Item No	Audit Team Comments		Audit Team Recommendations	Designer's Response
Checklist 2.1 – General				
2.1.1	Summary:	Risk of vehicle conflicts with pedestrians	1. It is recommended that the Designer reviews whether a sign warning vehicle drivers of the possible presence of pedestrians is required. 2. Approximately 100m to the east of the connection point, there is a footpath along the north side of Courtwick Lane commencing at Kingfisher Drive, and perhaps a link from the carriageway to the west end of that footpath could be provided to remove pedestrians from the carriageway at that point.	1. Agreed. A warning sign to diag. 544.1 has been indicated on the drawing, located adjacent to an existing perking deterrent bollard, immediately west of a passing space on the nearside carriageway. 2. Disagree. The suggested footpath link would need to be constructed over third party land and there would be third party land issues and potential long term maintenance problems if no one wished to take ownership.

Location:	<i>A (drawing 4485/314 B)- Courtwick Lane</i>		
	Description:	Courtwick Lane is narrow, and in places barely wide enough for a vehicle to pass a pedestrian walking in the ca

Drawing Number				Rev.
4485/314				E

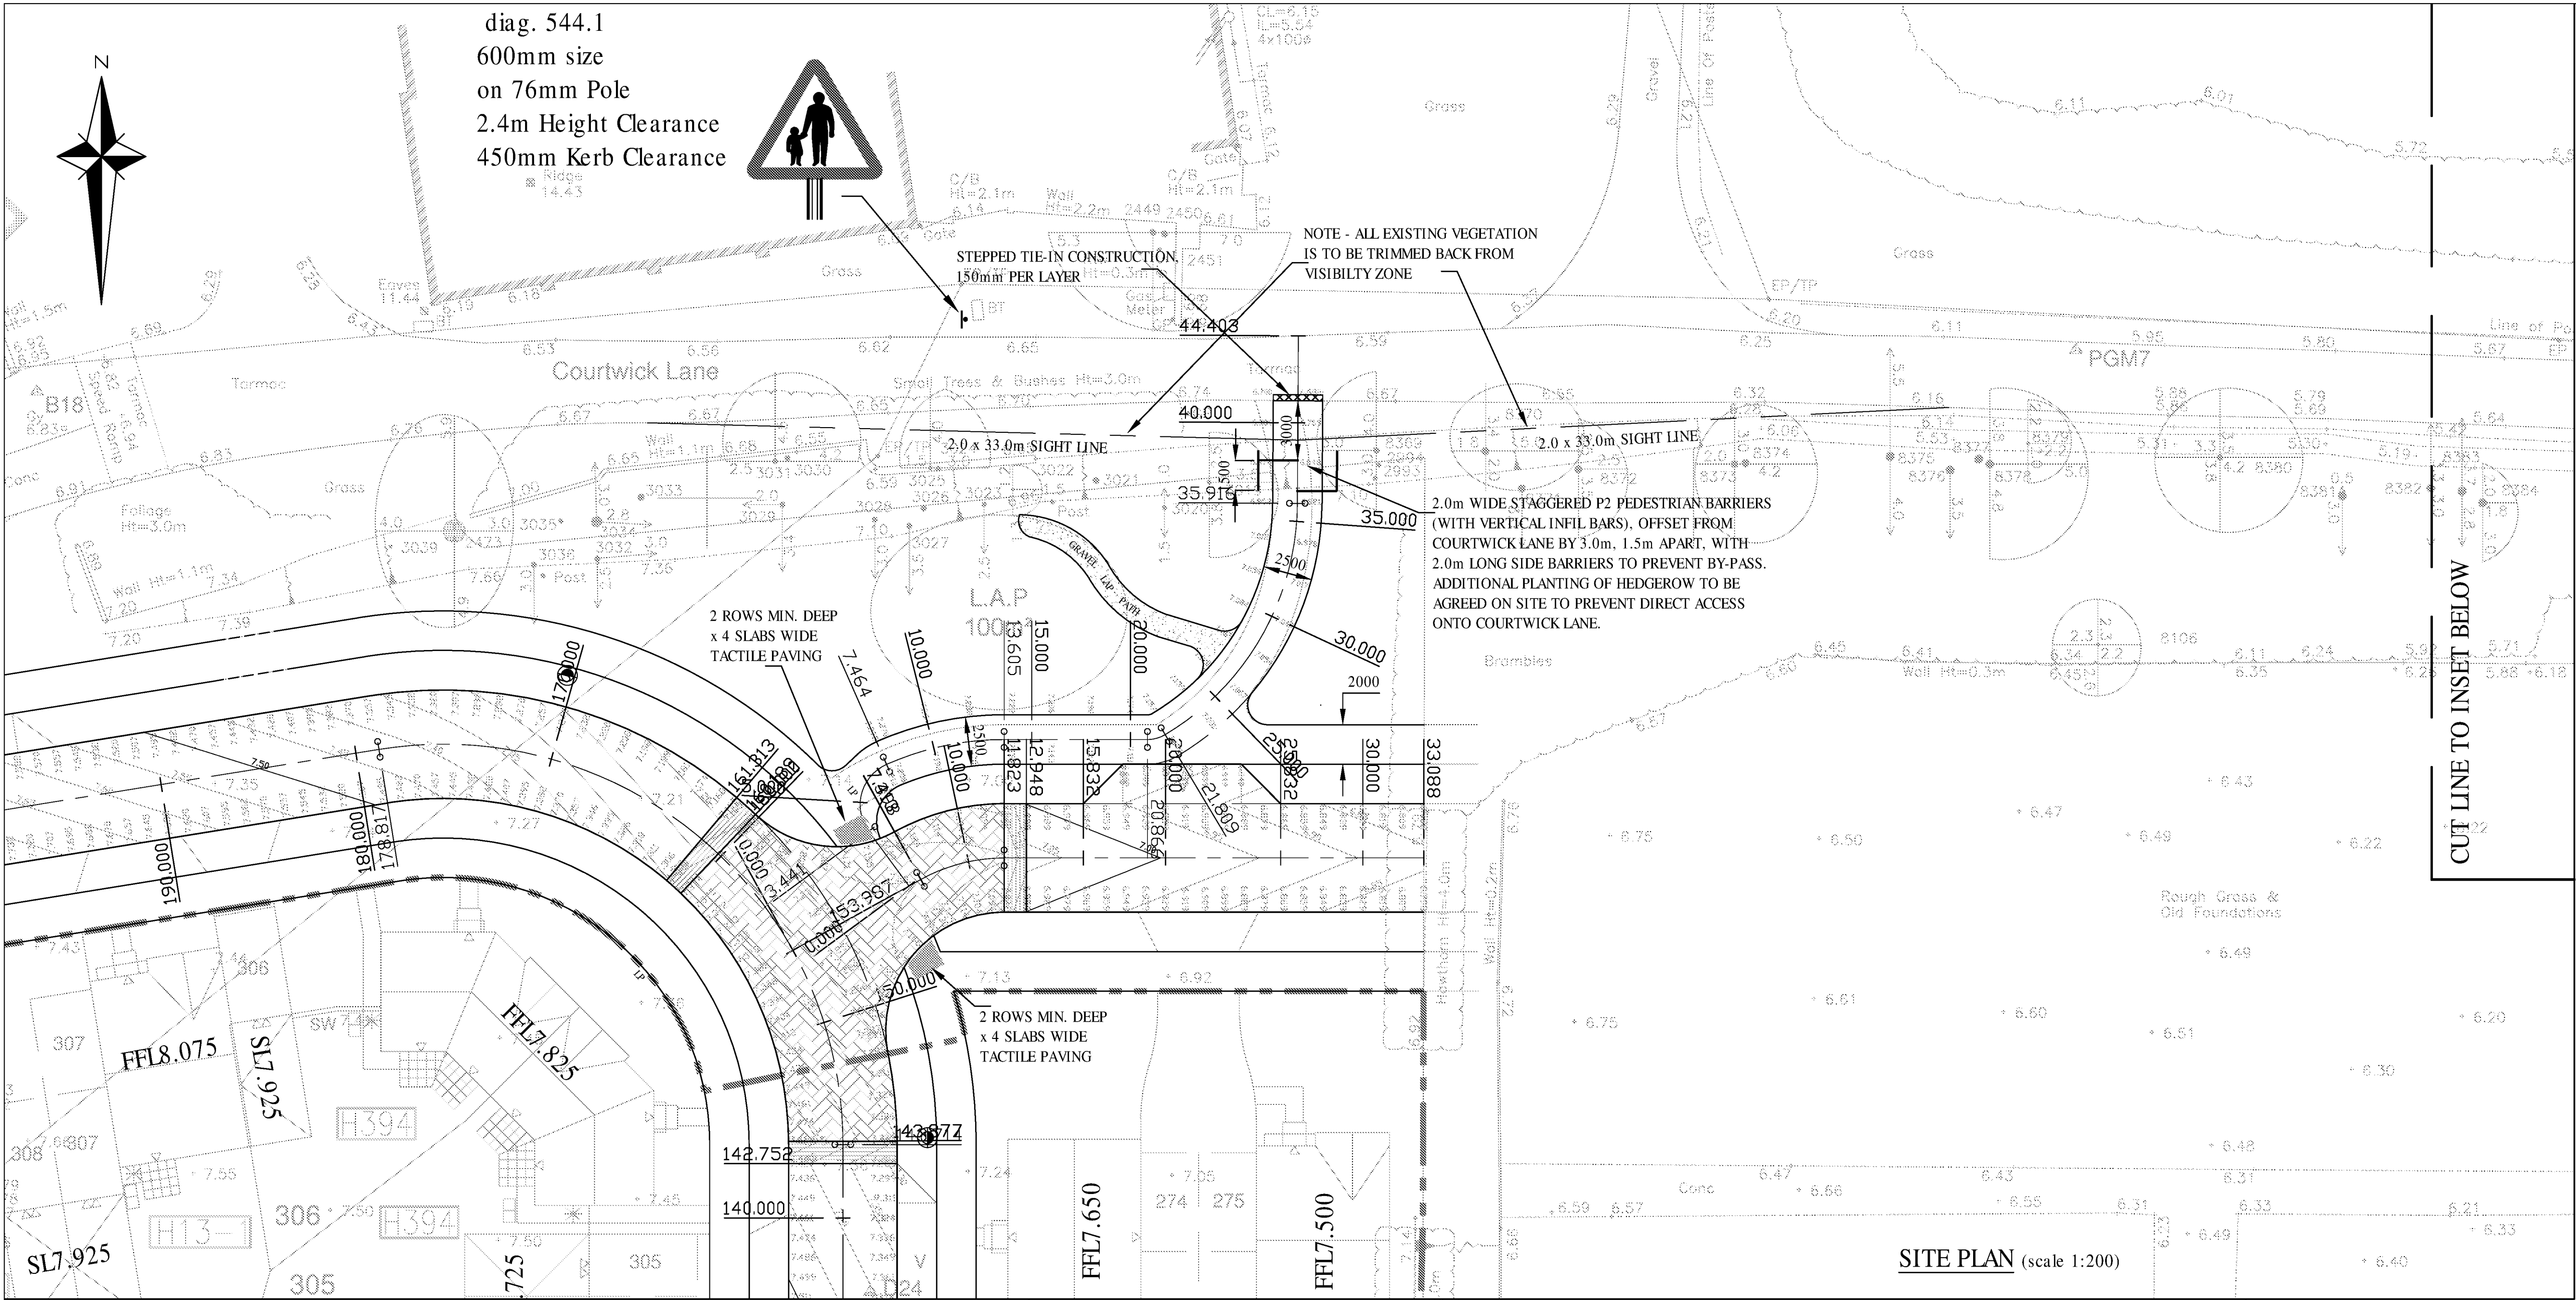
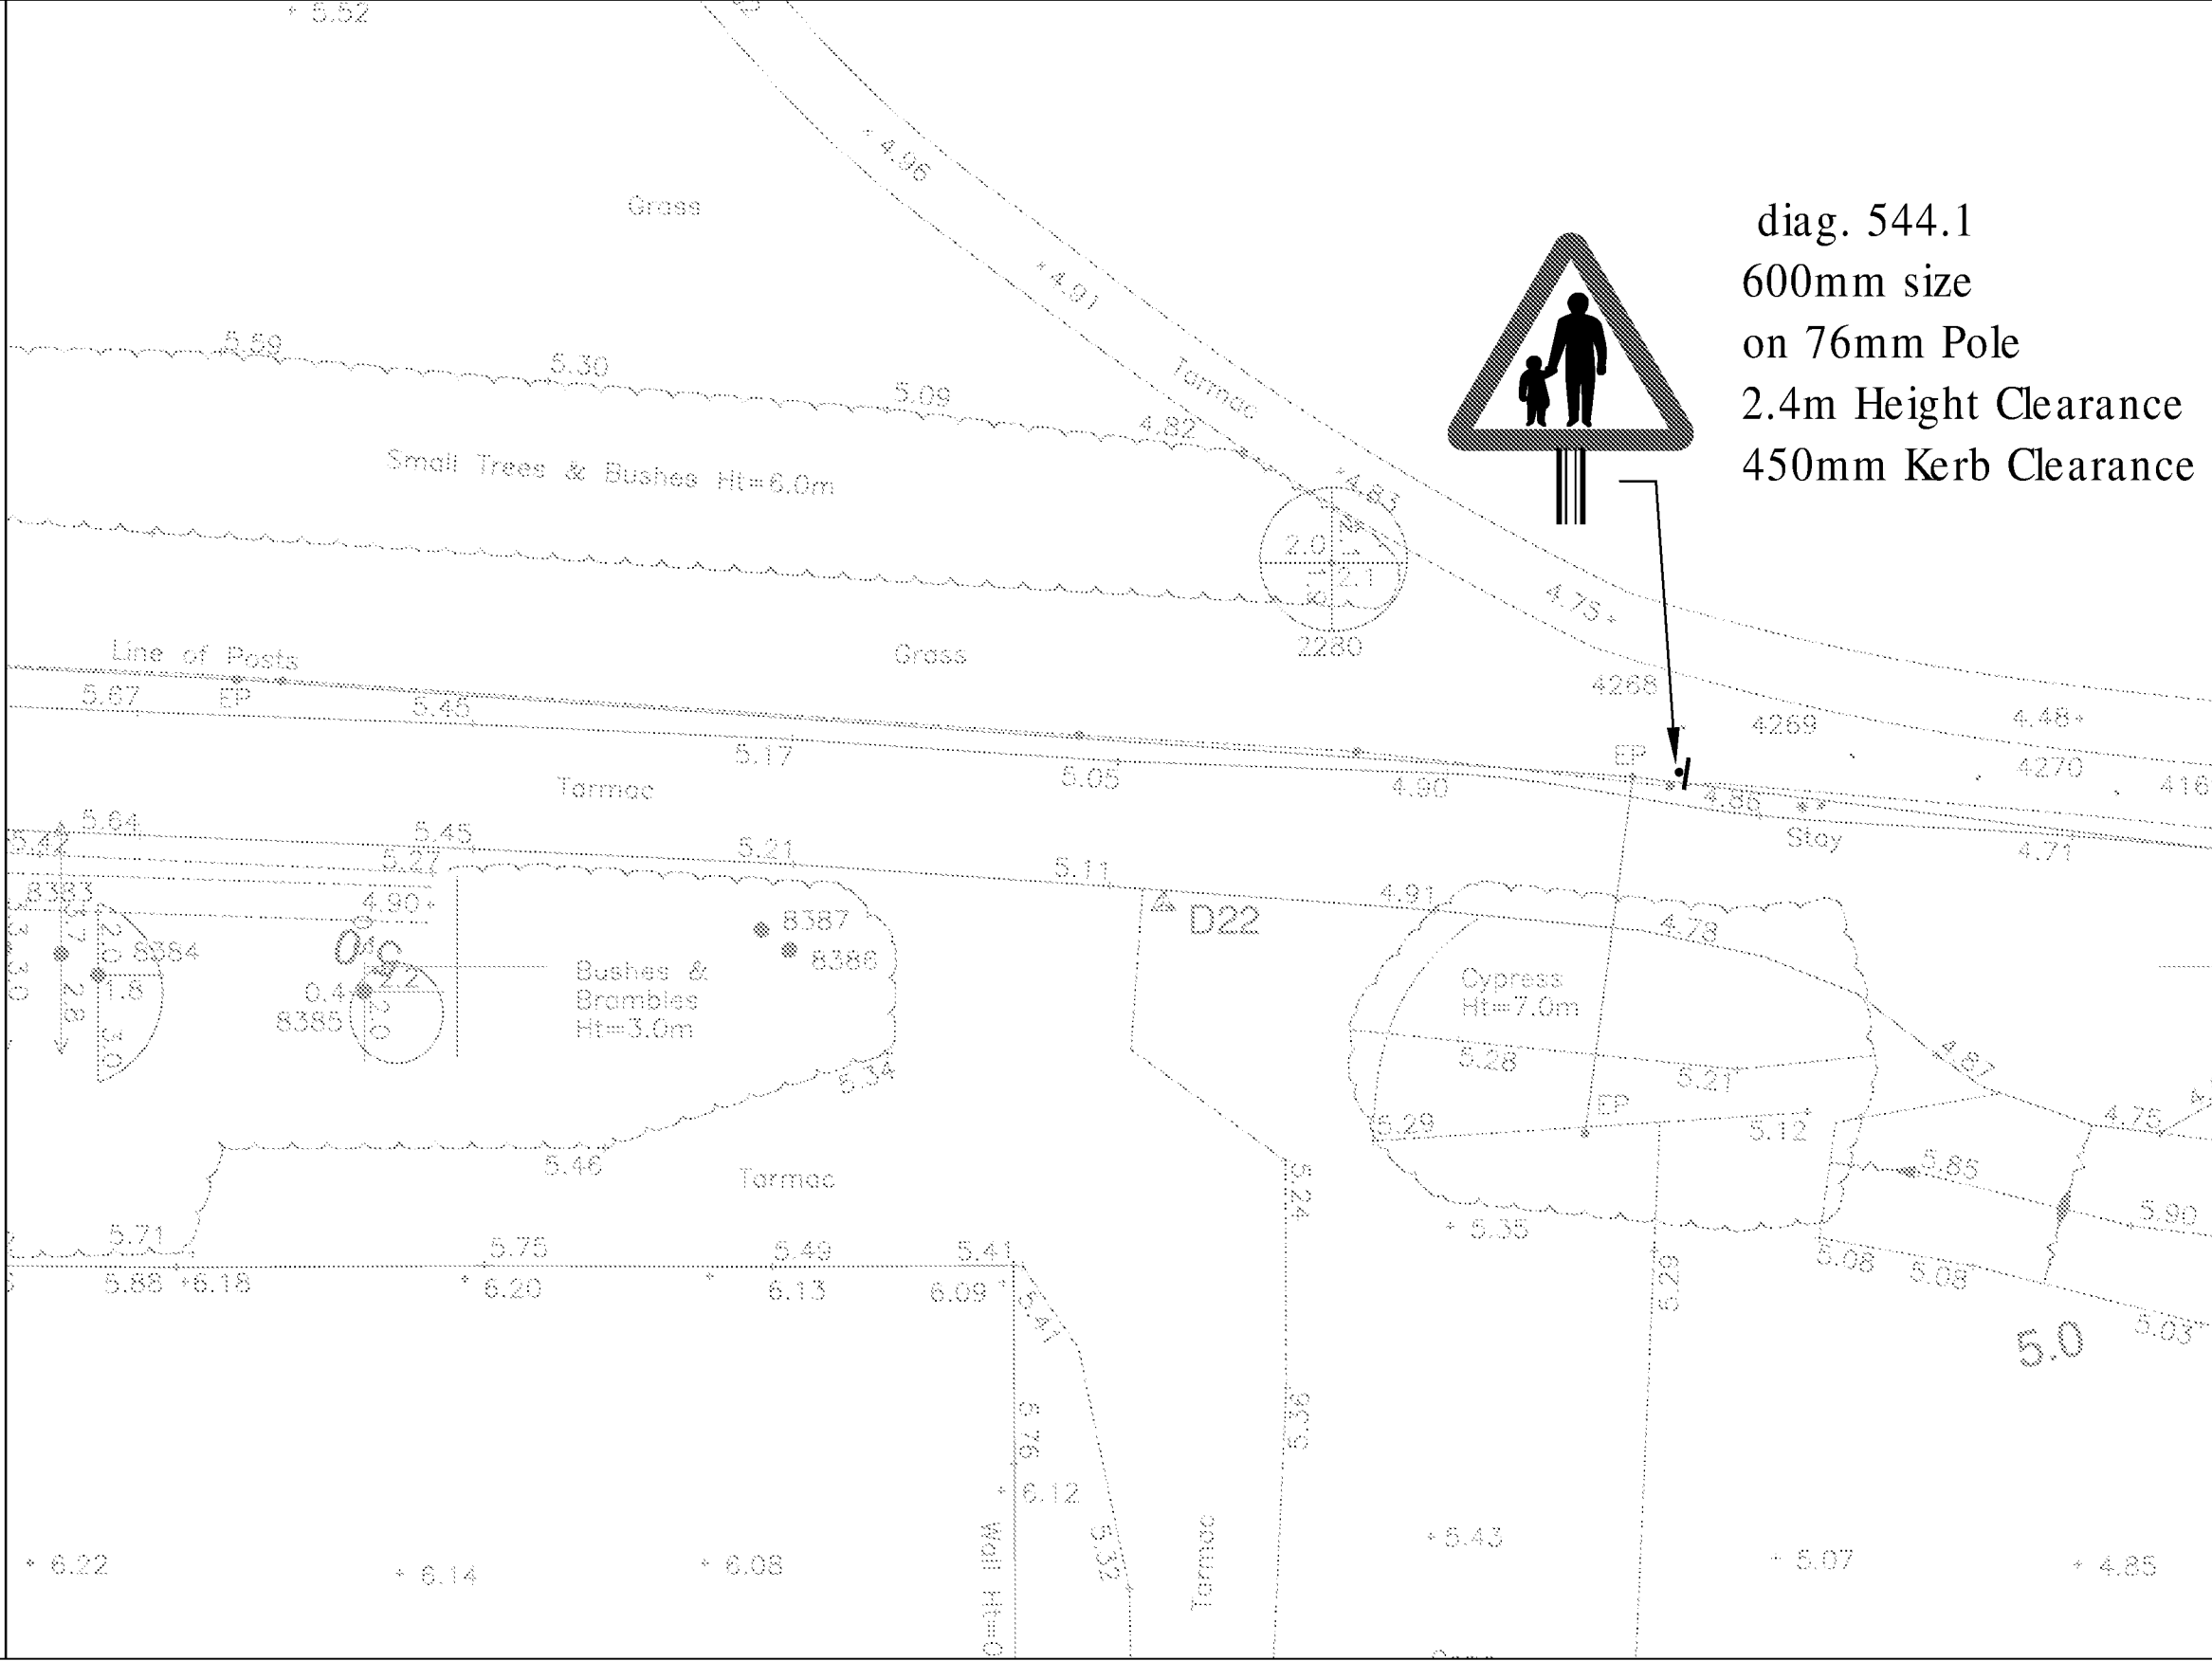
2.4.1	Summary:	Risk of trip on high kerb upstand	It is recommended that the paving is aligned across from one side to the other.	Agreed. Tactile paving has been realigned on the drawing.
	Location:	<i>B (drawing 4485/314 B)- Ernest Fitches Way</i>		
	Description:	The tactile paving shown at the side road junction does not align from one side to the other. This will result in upstand kerbing opposite, and possible risk of trip by a visually impaired pedestrian.
